From: Rich Elliott <elliotr@kvfr.org>
Sent: Monday, January 27, 2014 5:08 PM
To: Jeff Watson; Lindsey Ozbolt
Cc: Joe Seemiller; John Sinclair; Brenda Larsen
Subject: RE: Kittitas County Notice of Application SP-13-00006 Willard Lot 2

Willard Lot 2 Short Plat SP-13-00006

WILLARD LOT 2 SHORT PLAT
 PART OF SECTION 25, T. 18 N., R. 18 E., W.M.
 KITTITAS COUNTY, WASHINGTON

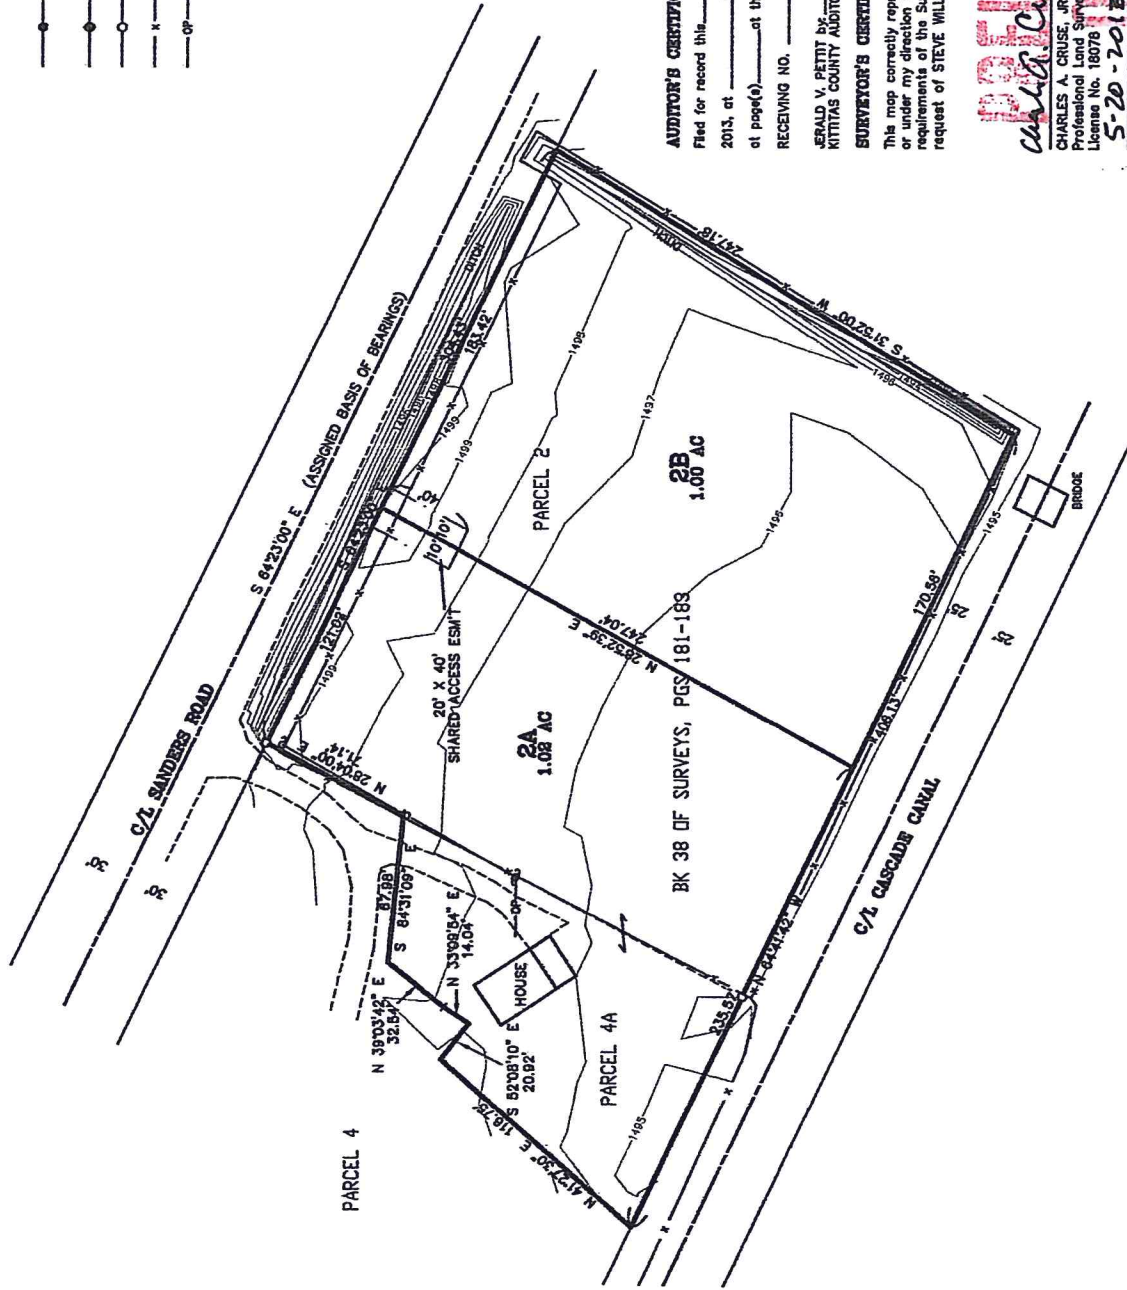
- We request that applicant be informed that access will need to comply with Appendix D of the IFC (current version) at time of construction.
- Also, these lots are adjacent to the City of Ellensburg. When developed, will these lots be serviced by fire hydrants? If so, KVFR requests to be included in the decision as to placement of hydrant(s).
- Addressing will need to be visible from both directions of travel on Sanders Road.
